Our Case Number: ABP-316178-23

An
Bord
Pleanála

Date: 09 October 2024

Re: Proposed development of Oweninny Windfarm Phase 3 consisting of 18 no. wind turbines.
Within the townlands of Laghtanvack, Croaghaun (also known as Croaghaun West), Moneynieran, Corvoderry, Shanvolahan, Dooleg More, Shranakilly, Bellacorrick and Shanvodinnaun, Co. Mayo.

Overview Sheet

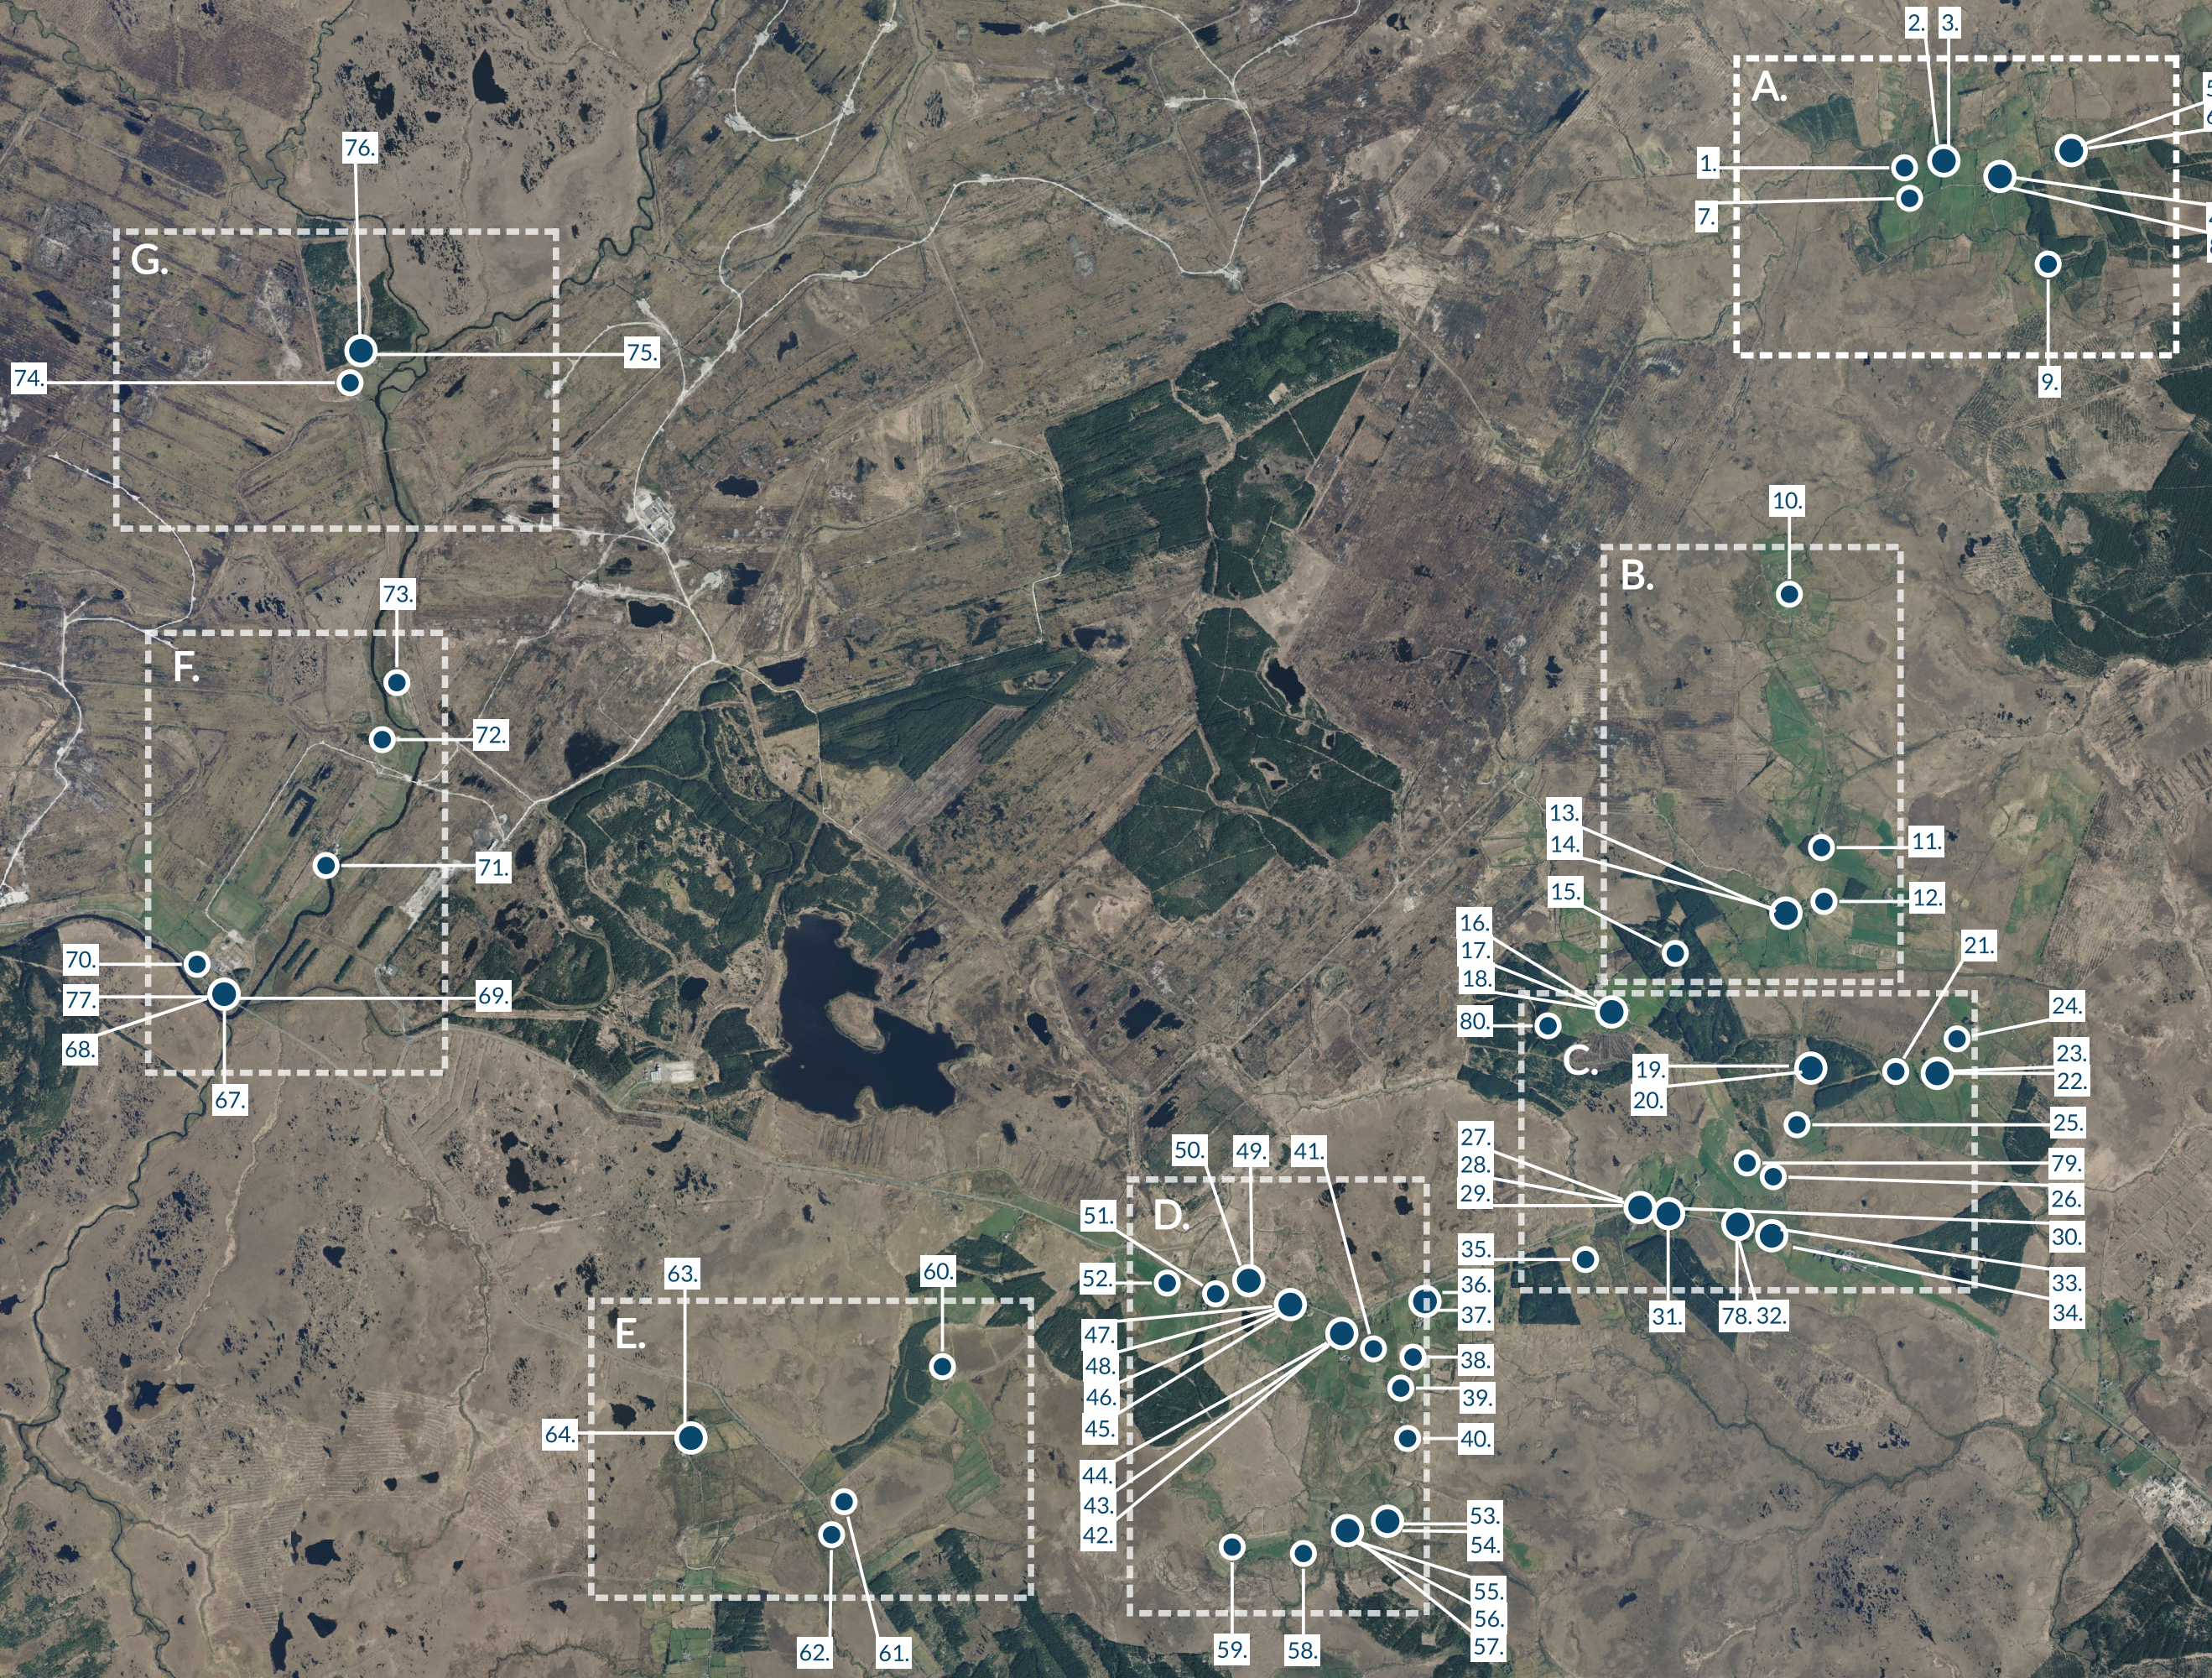
- The shadow flicker is assessed in Chapter 14 of the EIAR. Receptors are stated to be detailed in Figure 10.1, however there are no Figures in this chapter (Figure 10.1 relates to a site location map in the hydrogeology chapter).

- In Chapter 14 it states that a total of 78 number sensitive receptors were identified and are presented in Table 14.1. Each receptor identified has been assigned an ID number for reference i.e. 1 to 78. It further states that the co-ordinates (ITM) of each of the receptors have been compiled and their locations added to the WindPRO model and that the co-ordinates of each of the receptors are listed in Chapter 6 (Population and Human Health) and are not replicated in Chapter 14.

- In Chapter 6, Figure 6.2 includes a map of sensitive receptors. These are not labelled but are a series of dots. Table 6.3 presents a summary of identified receptors i.e. total number Of SR of commercial, residential, both and unknown. No coordinates are provided, nor are they labelled in any map in the planning documentation.

1. The ITM and Eircode of each of the 78 number shadow flicker receptors with an annotated map indicating each of the receptors.
